From: Patel, Uday [Uday.Patel@lancashire.gov.uk]
Sent: 22 February 2013 14:59
To: Claire Booth
Cc: planning
Subject: 3/2013/0055 - Proposed 3rd double bedroom over existing kitchen extension and site car parking and turning area - Rose Cottage Main Street Grindleton BB7 4QT

Planning Application reference: 3/2013/0055
 Proposal: Proposed 3rd double bedroom over existing kitchen extension and site car parking and turning area
 Location: Rose Cottage Main Street Grindleton BB7 4QT

Uday Patel
Developer Support
(Environment Directorate - Lancashire Highway Services)

Title **Site Layout**

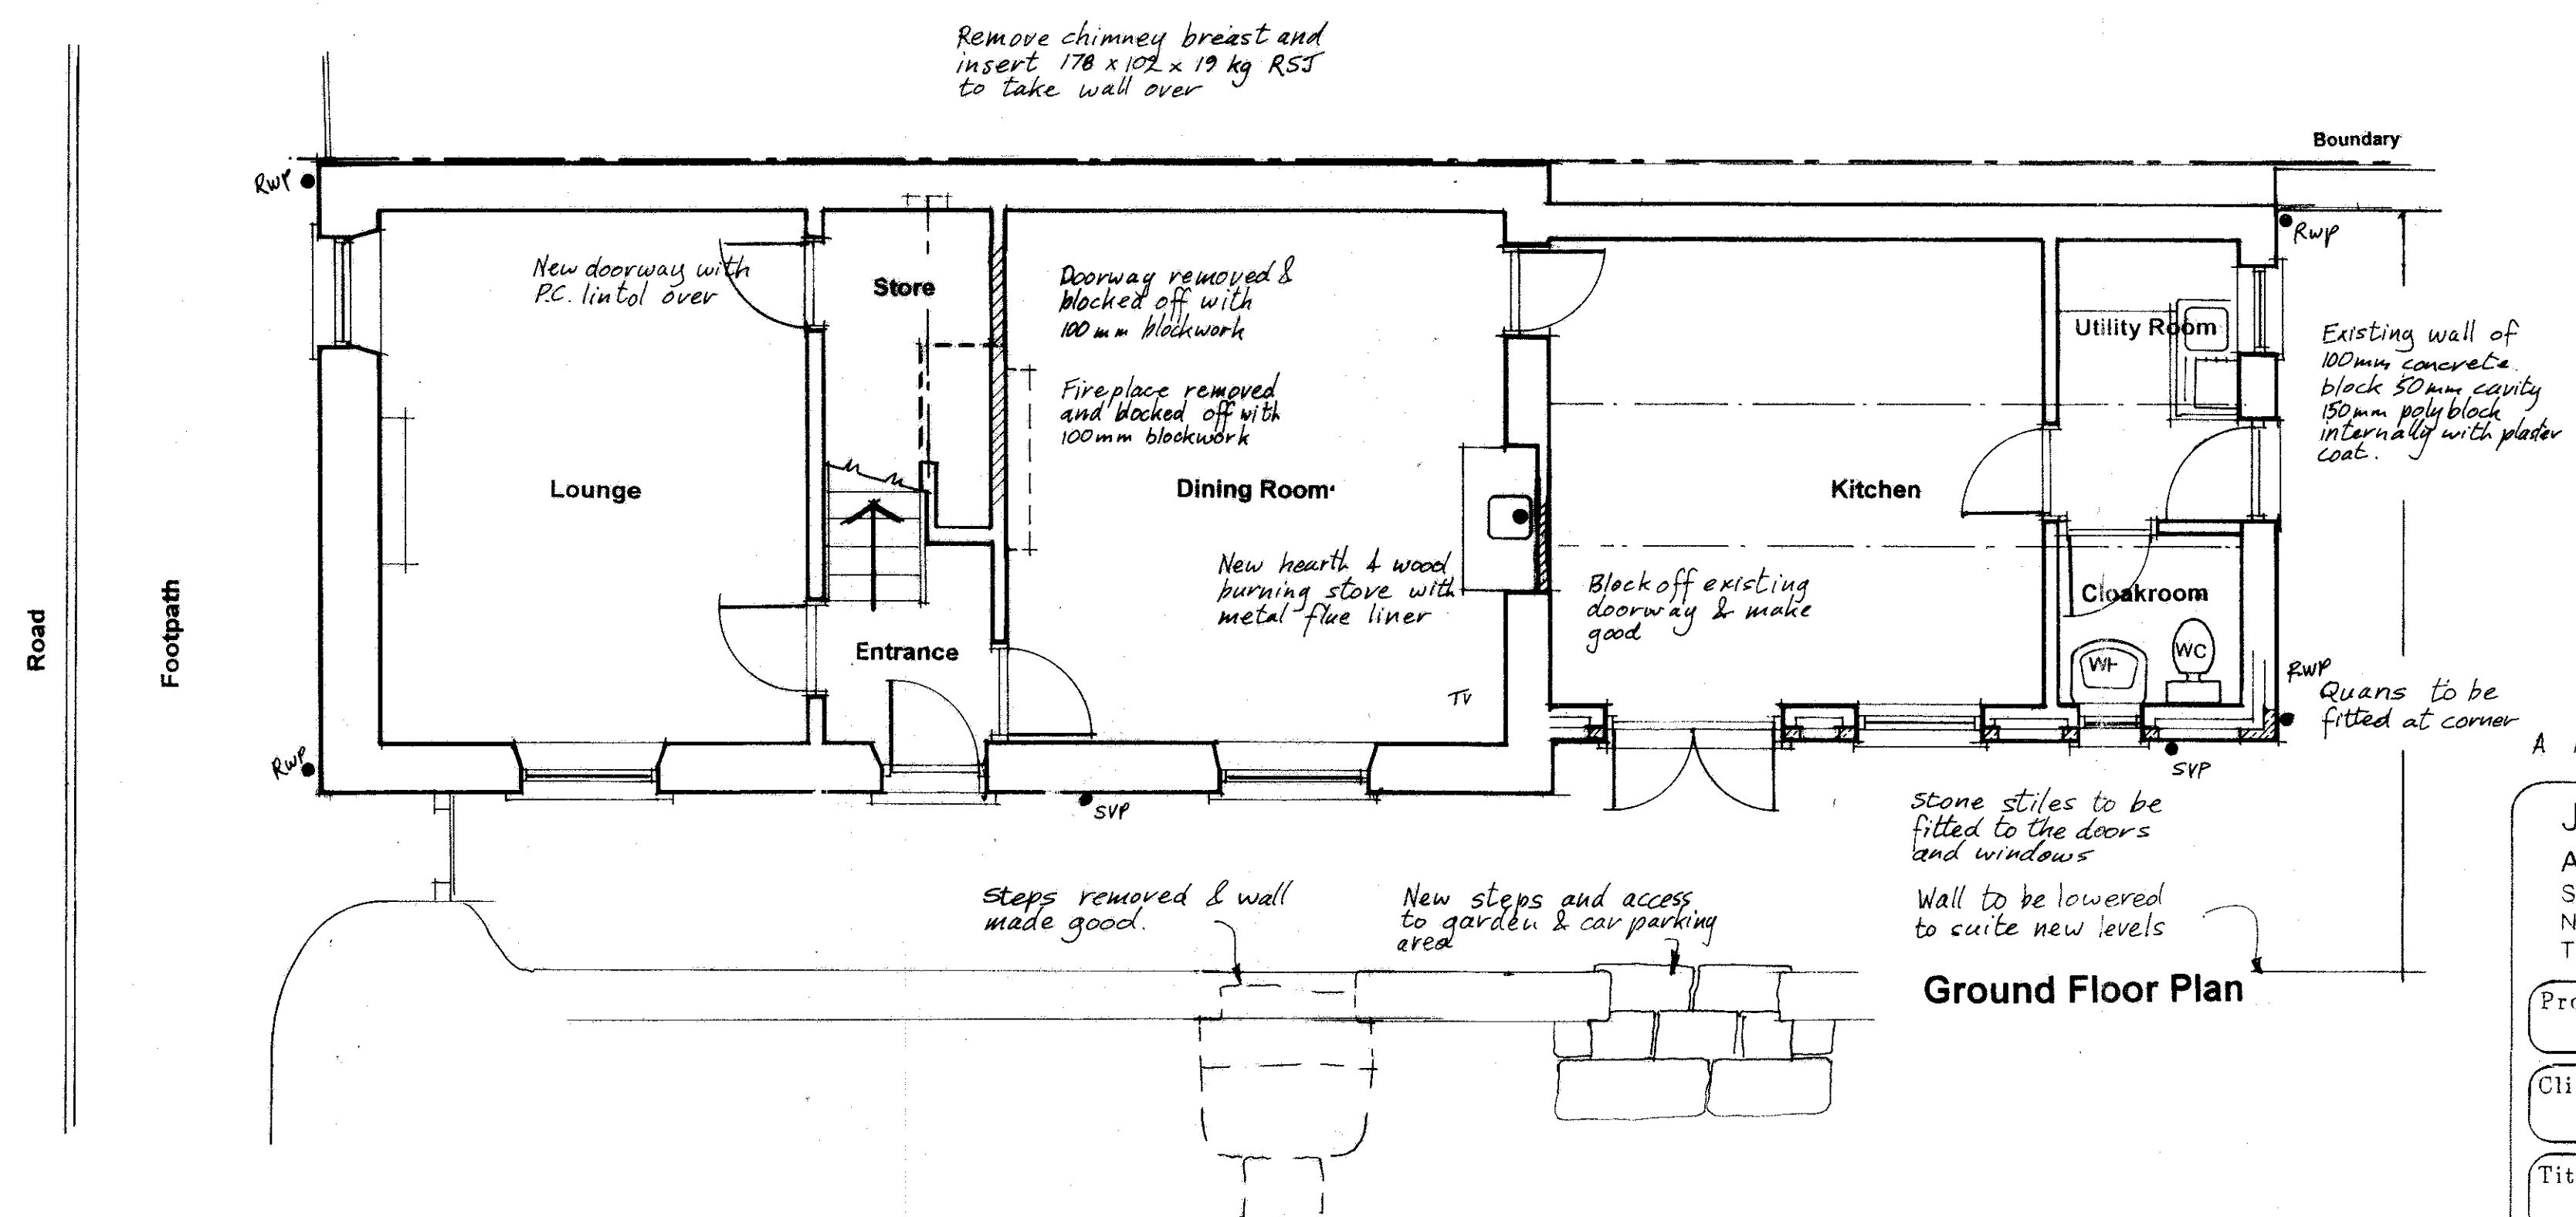
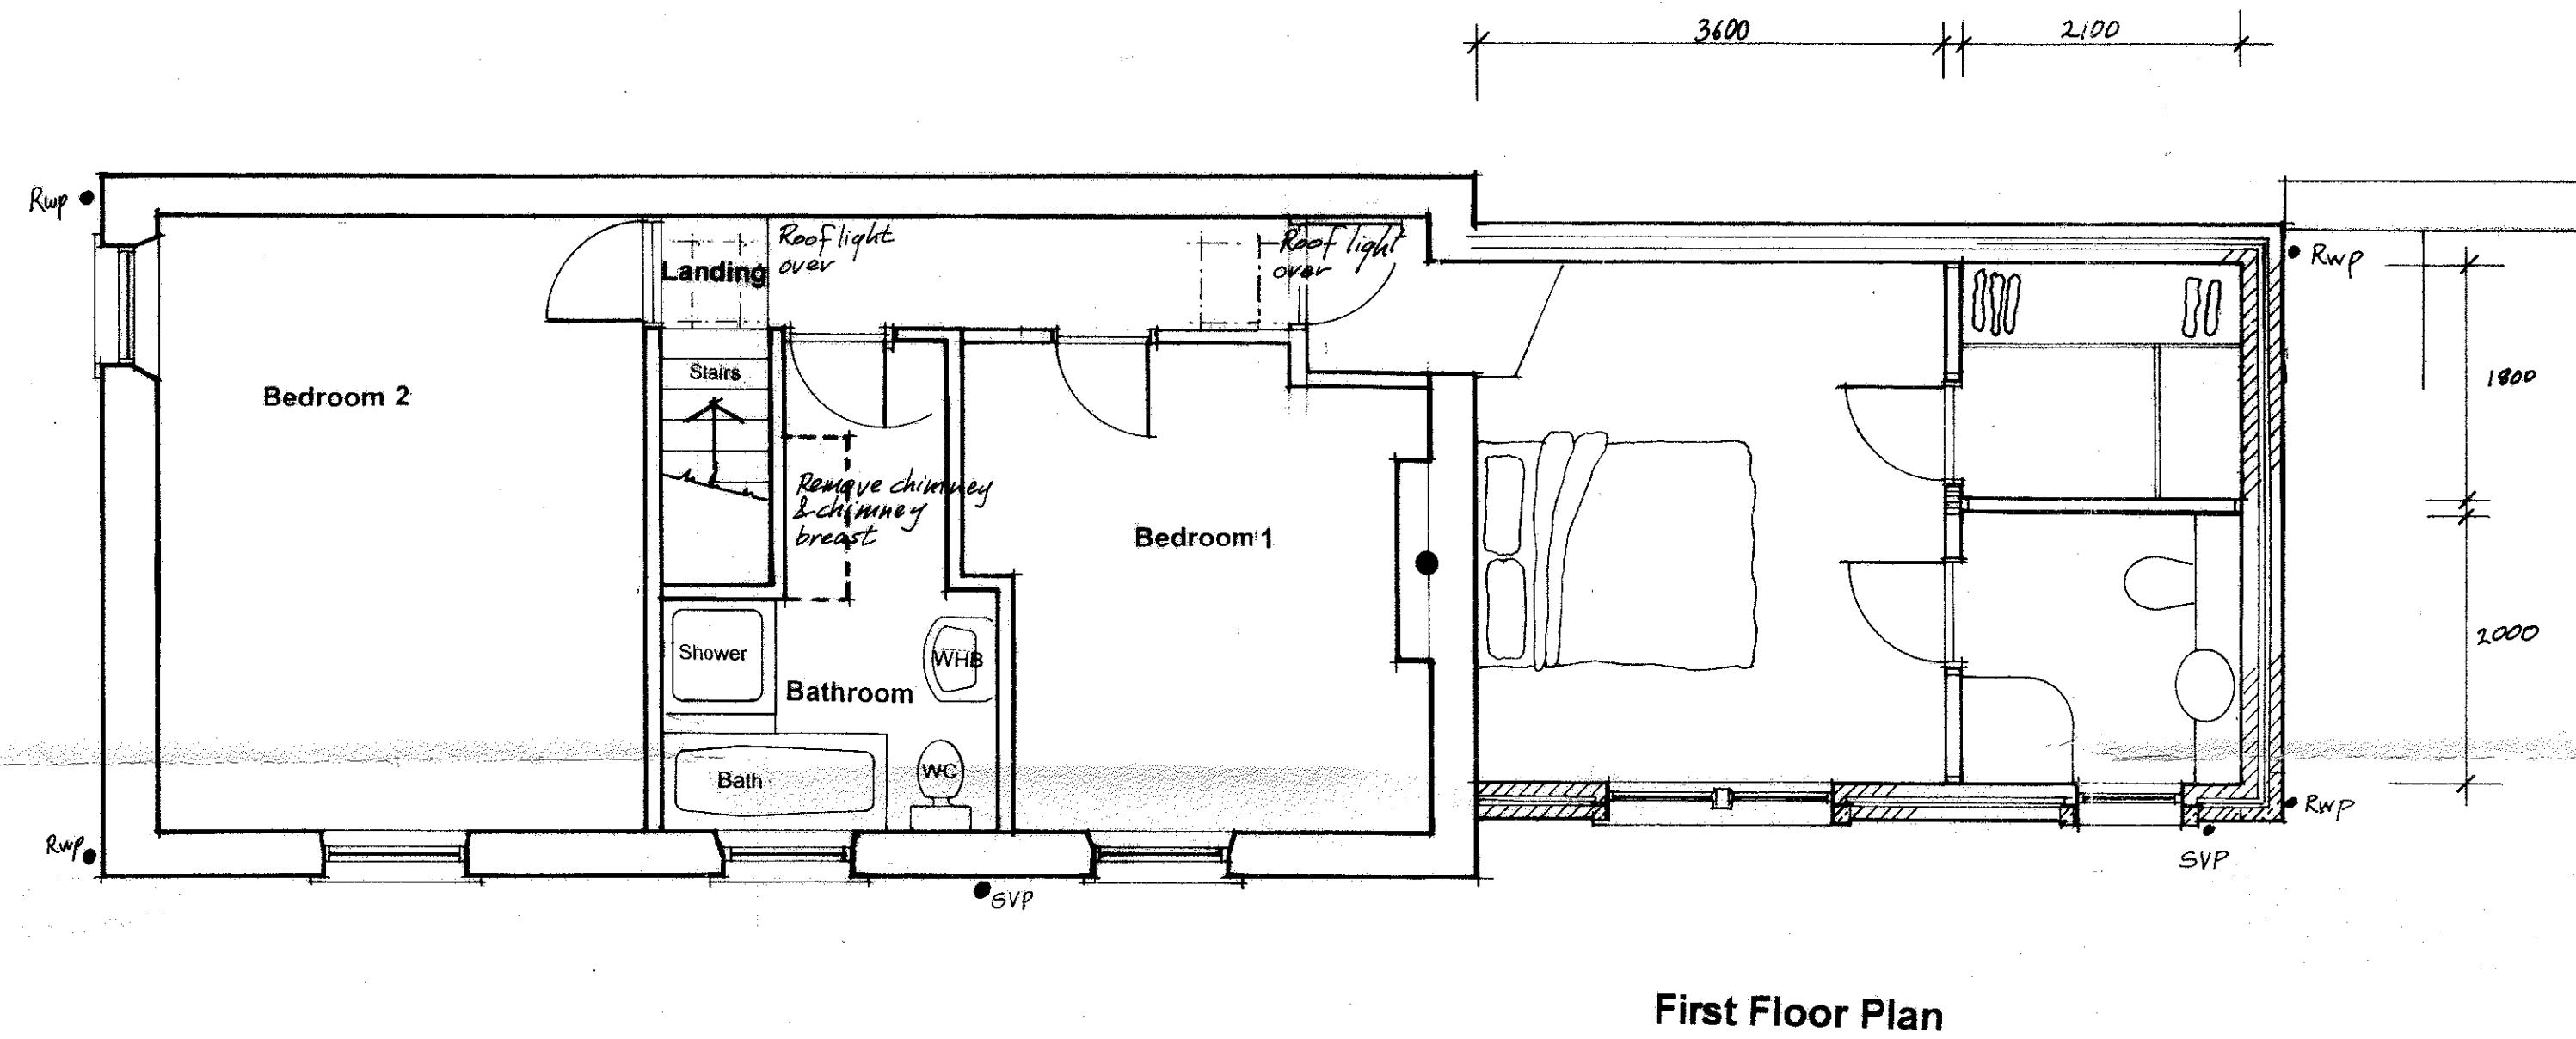
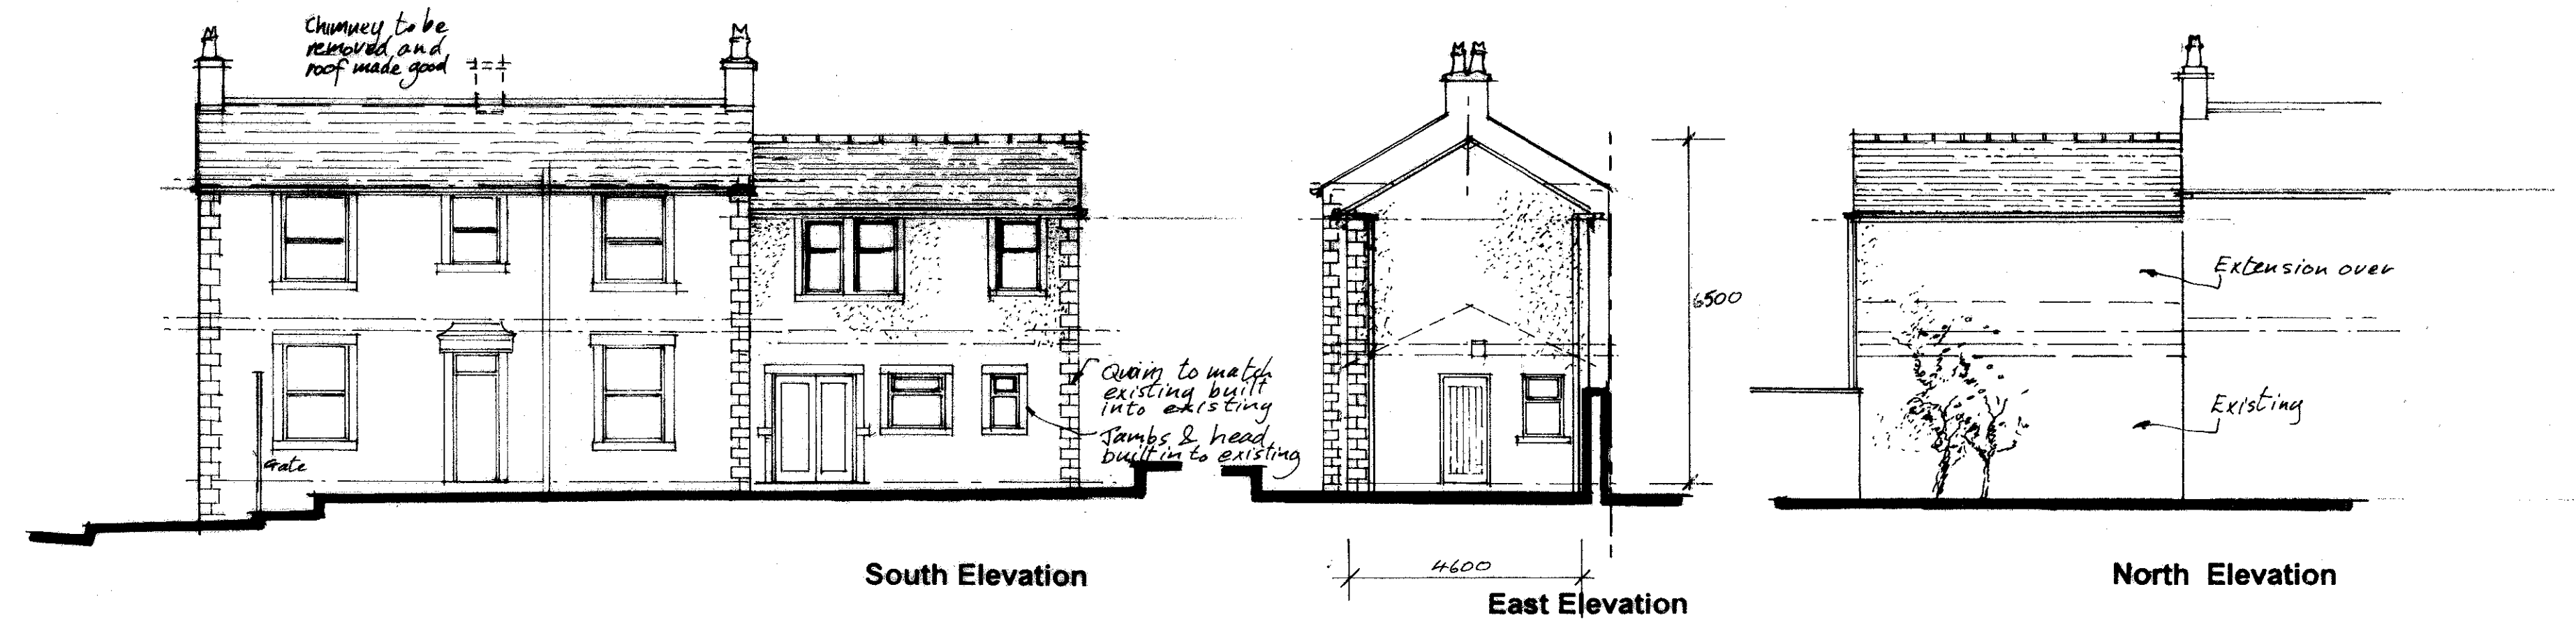
The proposal involves creation of additional bedroom within the property. According to JLSP domestic parking standards guidelines, 3 bed room dwelling will require 2 no parking spaces within the curtilage of the property. Proposal indicates demolition of existing detached garage and provision of vehicle turning space as well as parking of 2 vehicles within the curtilage of the property. It is noticed that there is a stone wall to the north of the existing drive way. Currently there is almost no visibility in the north direction due to the existing stone wall. Also in south direction of the existing access the visibility is limited to about 12m only. This is considered to be of substantial substandard nature. Although there is unlikely possibility to improve the visibility in south direction because of the third party property, there is likelihood of improving the visibility in north direction by taking down the stone wall adjacent to the drive way. It is noticed that there is an existing wooden fence along the frontage of the property along Main Street. This is likely to affect the improvement of visibility by taking down the stone wall.

- The layout of the development shall include provisions to enable vehicles to enter and leave the highway in forward gear and the vehicular turning space shall be laid out and be available for use before the development is brought into use. Reason: Vehicles reversing to and from the highway are a hazard to other road users.

- Before the development hereby permitted becomes operative, the existing wall on the highway frontage of the site to Main Street shall be reduced to and be permanently maintained henceforth at a height not greater than 900mm above the crown level of the carriageway of Main Street. The wooden fence over the existing stone wall to the frontage of the property shall be removed to improve the visibility. The stone wall adjacent to the existing drive way shall be removed to improve the visibility. Reason: To ensure adequate visibility for the drivers of vehicles entering and leaving the site.

- The proposed access from the site to Main Street shall be constructed to a (minimum) width of 3.5m at the back of the footway. Reason: To enable vehicles to enter and leave the premises in a safe manner without causing a hazard to other road users.
